Application number: 2023/92383	
What is the application for?:	Erection of two storey and single storey rear extension with terrace above and a
Address of the site or building:	11, Moorside Court, Moorside, Cleckheaton, BD19 6AY
Postcode:	BD19 6AY

SOUTH ELEVATION  
1:100

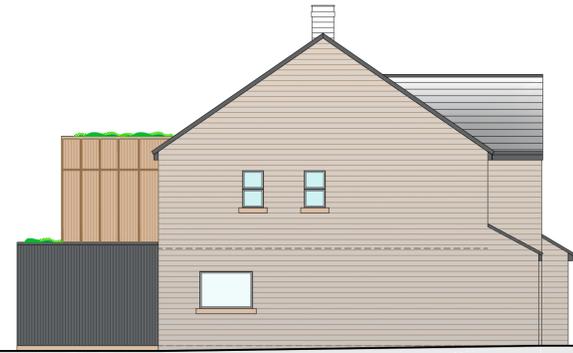
Type of comment: An objection	
Do you wish your comments to be published on the website anonymously?	Yes
<p>The materials used in the extension are not in keeping with the style of the development as the development is in stone.</p> <p>There are a lot of conservation and nature features within the development, mainly bird and bat boxes that were part of the original planning permission with Kirklees. The majority of the bird boxes are within the green spaces, however there are two very important ones in the centre of the development which are to the rear of the semi detached garages at numbers 1 & 3 Moorside Court. Please see Drawing Number 0200-0201 Accommodation Schedule. These garages are going to be very close to the extension and roof terrace which is going to have a detrimental impact on the swifts and swallows that nest on the development. The increased noise from the elevated terrace will affect adjoining properties and the bats, birds and nature of the development</p> <p>Starlings nest in the roof of Number 11 Moorside Court entering at the gable end every year. These birds are protected and will be impacted by this development.</p>
